Our ref: DOC20/987108

Your ref: MP06_0021-Mod 6

Angus Place Coal Mine - MOD 6 - Water Transfer System (MP06_0021-Mod-6)

Thank you for your email dated 26 November 2020 to the Biodiversity, Conservation and Science Directorate (BCS) requesting advice on the Angus Place Coal Mine and Springvale Water Transfer System Modification 6.

APPENDIX 2B – WATER SOFTENING PLANT

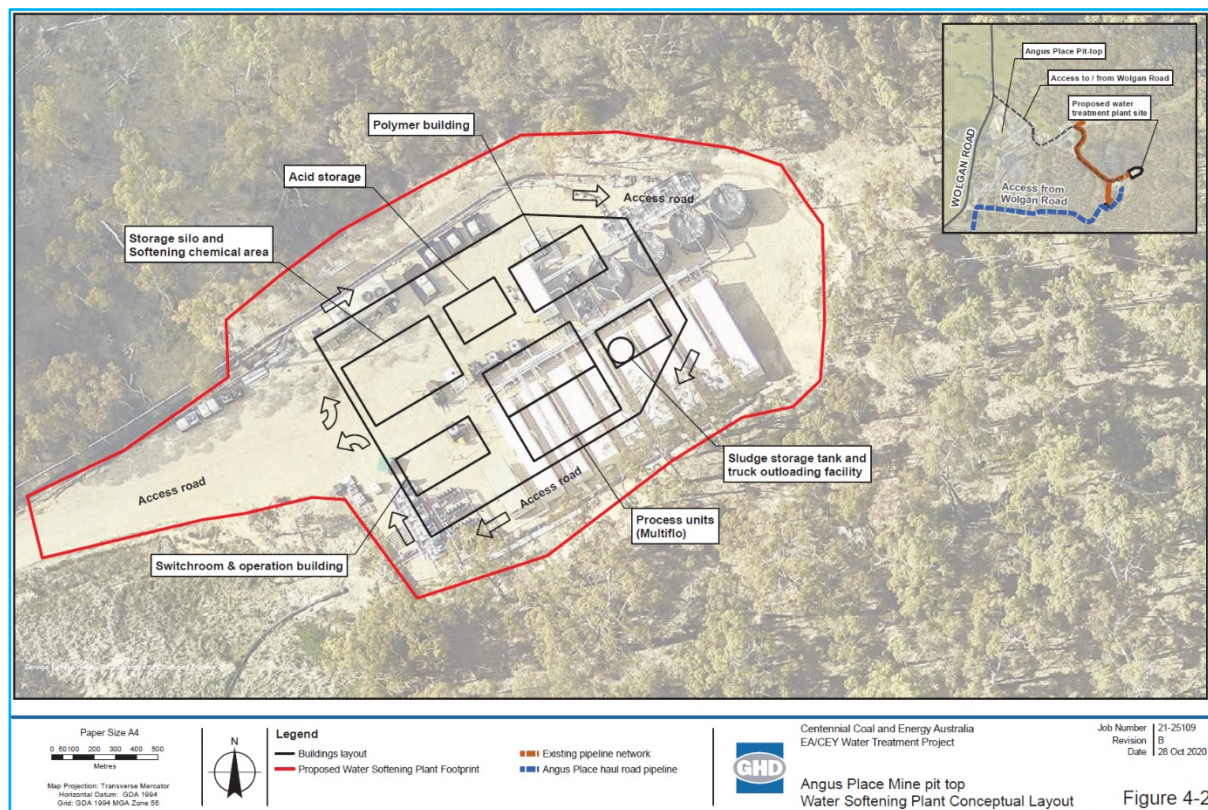
The water softening plant is to be constructed within the existing footprint at the Angus Place pit top. Section 6.1.2 of the modification report states that the proposed water softening plant would result in 'minimal additional construction footprint'. Figure 4.2 of the modification report indicates that the footprint for the water softening plant may extend into surrounding forest, potentially requiring removal of trees.

- 1.1 The proponent should advise whether there will be any additional clearing of native vegetation associated with the water softening plant. If so, a BDAR will be required for both the additional area to be cleared for the water softening plant and for the 0.0005 hectares of PCT 804 to be cleared for the water pipeline.
